**PLANNING REF: LU/116/21/PL – Land South Of The Littlehampton
Academy Fitzalan Road Littlehampton BN17 6ED**

**PRE-APPLICATION RESPONSE - HOUSING STRATEGY AND ENABLING MANAGER
ARUN DISTRICT COUNCIL**

ANNEX 1
AFFORDABLE HOUSING PLAN

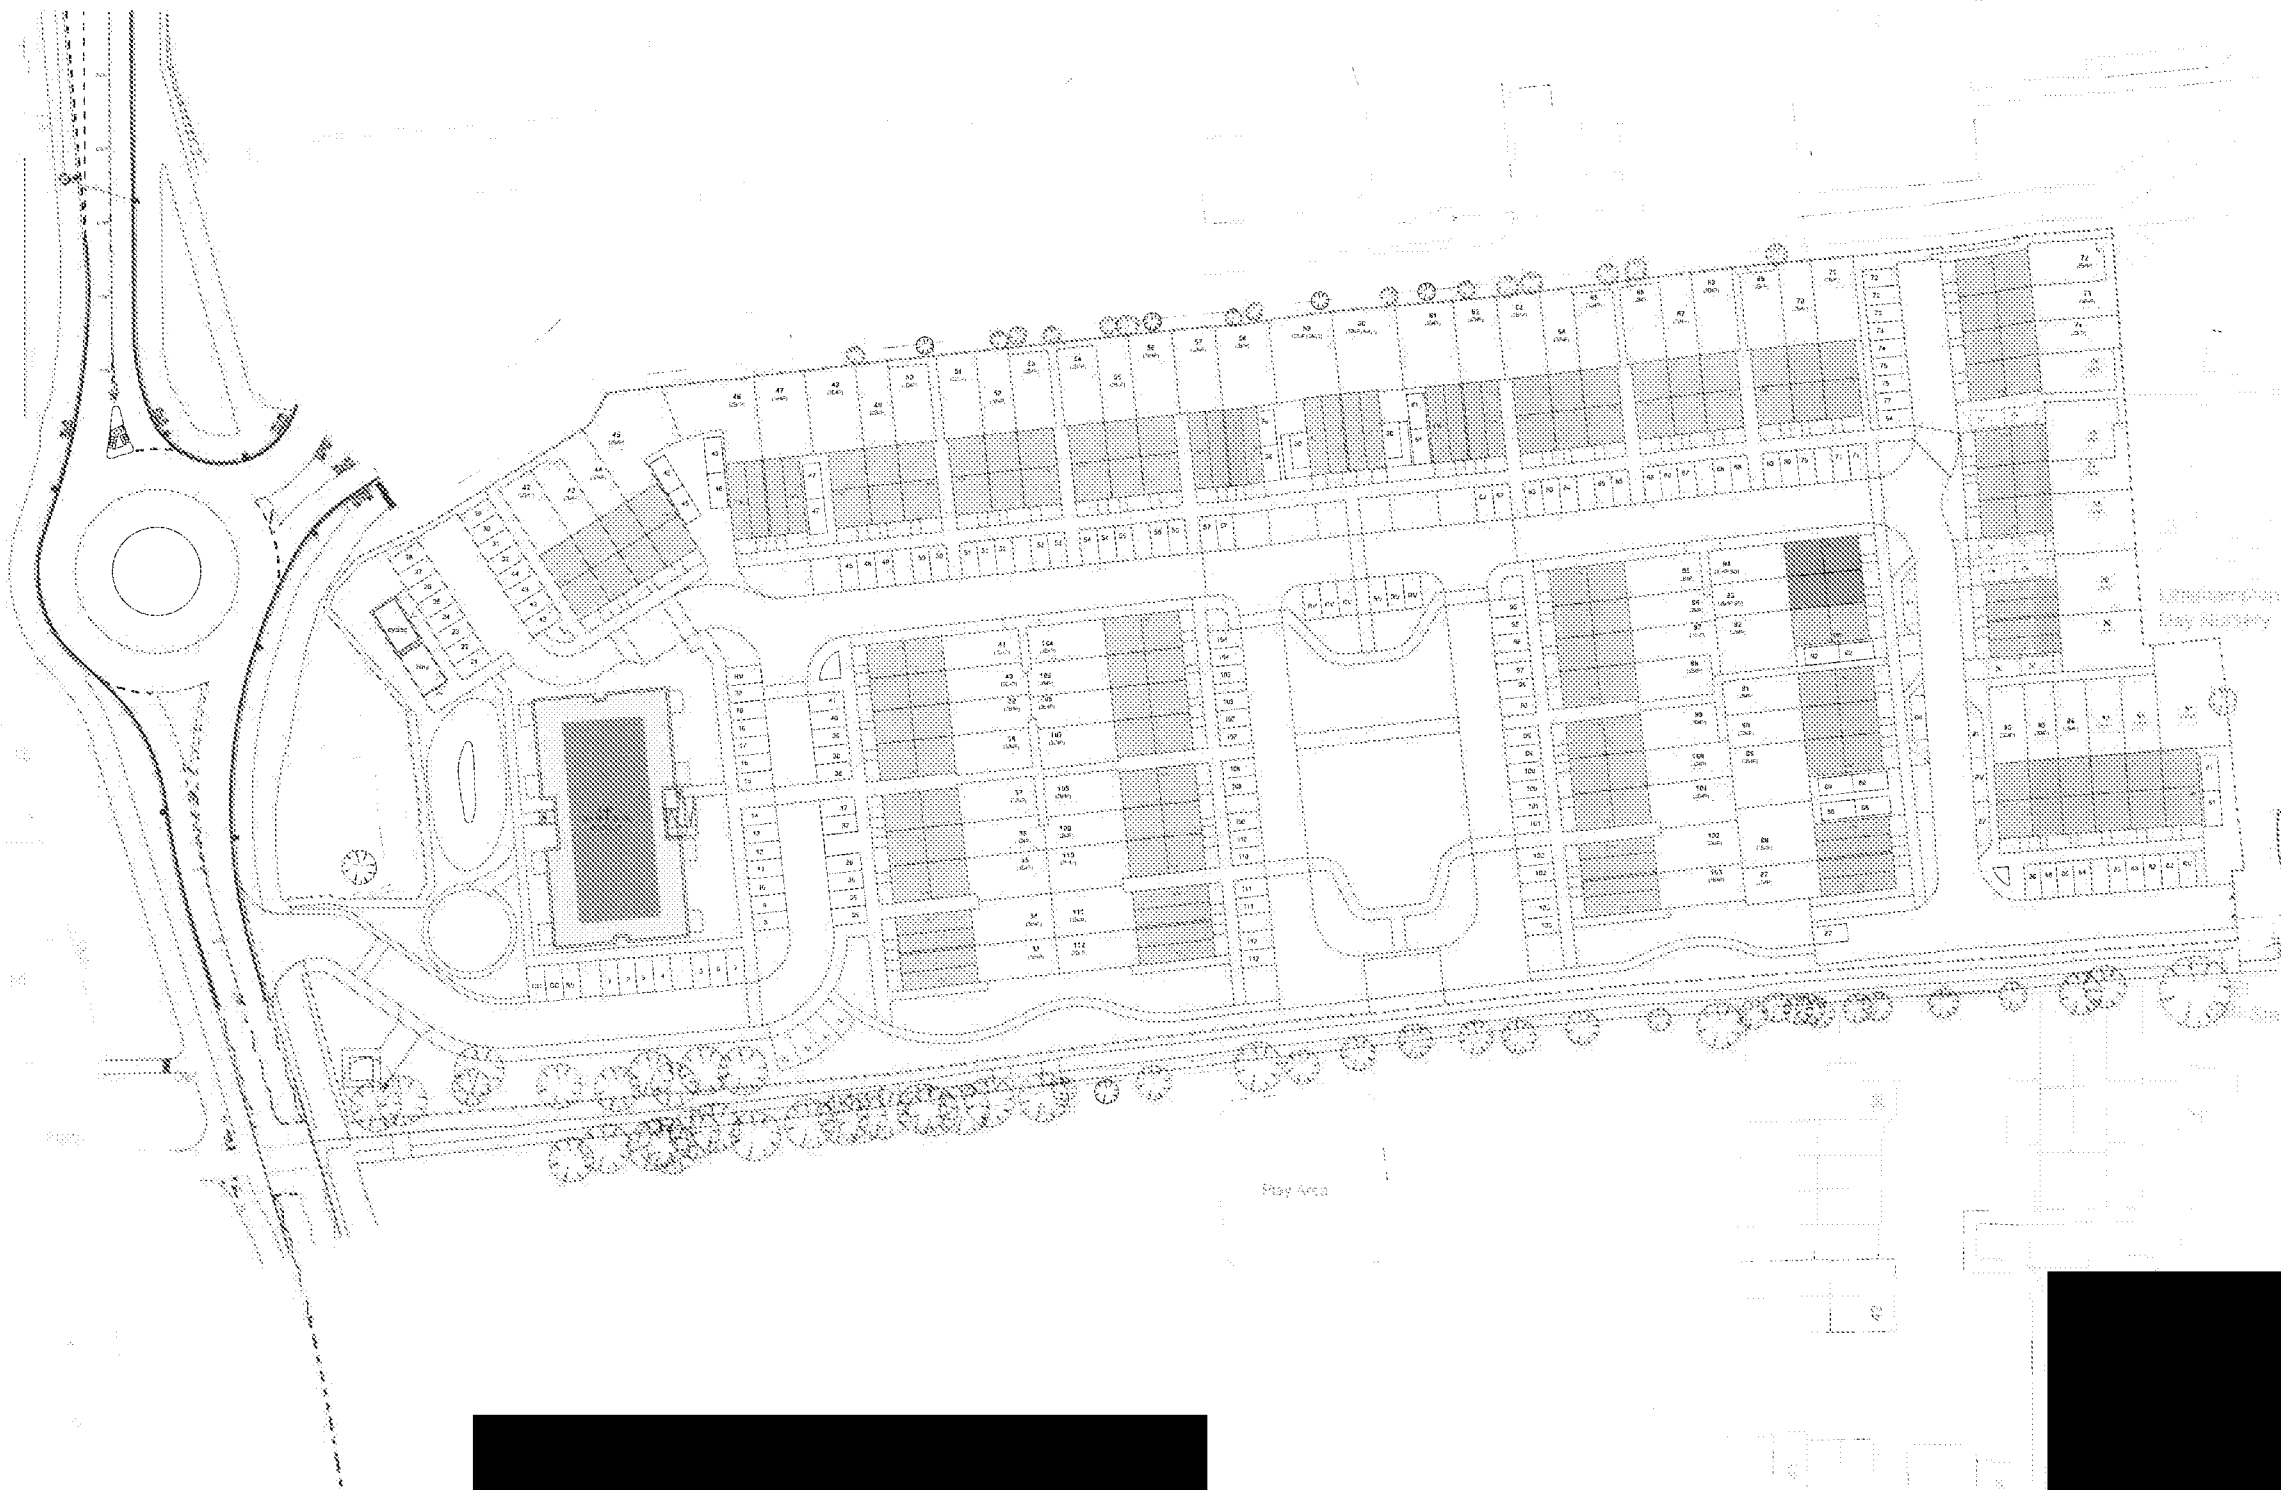
Following discussions, the applicant has proposed to amend the tenure mix by switching 2 x 2 bed houses from intermediate to rented tenure (as shown below). Whilst welcome this simply brings the tenure mix to (slightly above) the 75 rented / 25 intermediate tenure policy as set out in Policy AH SP2. Previously the mix was 71% rented.

Although the site as a whole is providing predominantly 2 and 3 bed houses all the affordable dwellings (with the exception of the 2 x 2 bed houses referred to above) are flats, which are heavily weighted in favour of 1 bed. This is contrary to the SHMA

Finally, there remains an issue with a lack of clustering which has all but two of the affordable in one block.
